**Consultation Response from KC,
Strategic Housing**

**2022/93938 First and Second Floors, Shopping Precinct, New Street and Albion Street,
Huddersfield, HD1 2TR**

**Change of use from A1 (business retail and storage) to C3 (residential) 18 studio flats at first
and second floors and external alterations**

Date Responded: 1st November 2023

**Accommodation Schedule**

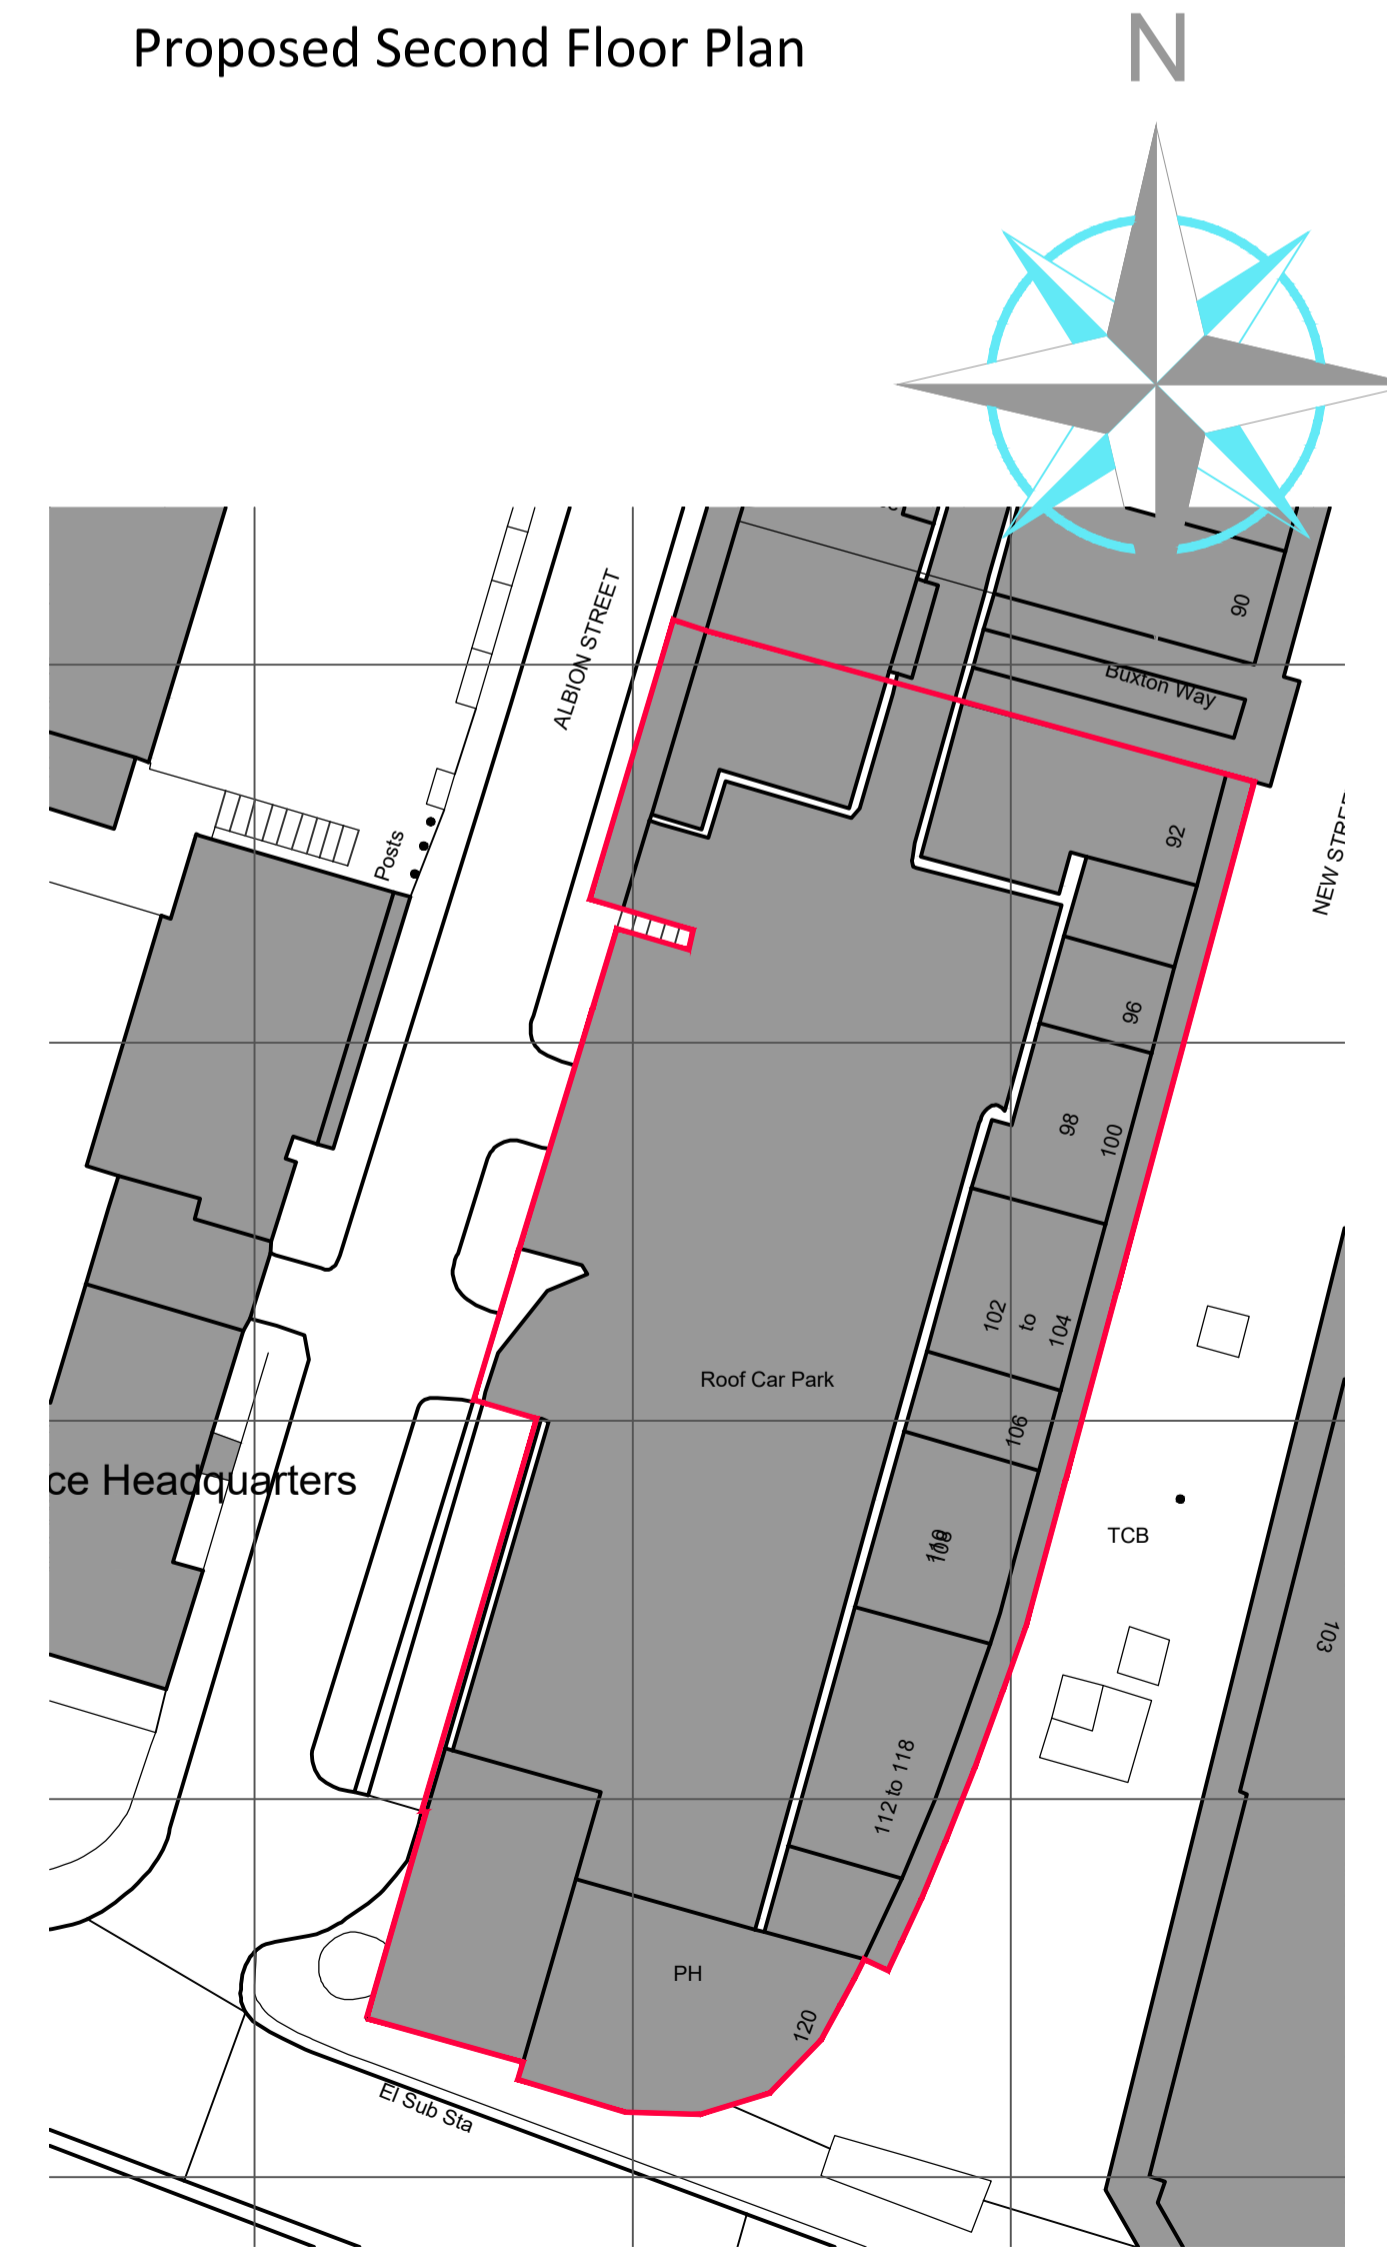
Type: The applicant has amended the total units of this development from 34 to 18 units. The applicant proposes a mix of 15 x 1 bed flat and 3 x studio flats. This proposal still does not meet the Council's aims to diversify the housing mix in Huddersfield Town Centre by providing a mixture of housing type. A more appropriate provision would be a mix of 1 and 2-bed properties.

Nationally Described Space Standards (NDSS): NDSS guidance states that one person with one bedroom should have a minimum floor space of 39 square metres, or 37 square metres if the dwelling has a shower room instead of a bathroom. The plans for this application for the studio flats and 1 bed properties are stated in the range of 37 square metres to 55.2 square metres. The plans show all dwellings to have a shower room. Therefore these units now meet the minimum requirements of the nationally described space standard if all dwellings are for one person with one bedroom. If they are intended at 1b2p dwellings, the minimum space standard increases to 50 square meters. Strategic Housing recognises that this is a significant improvement upon previous plans.
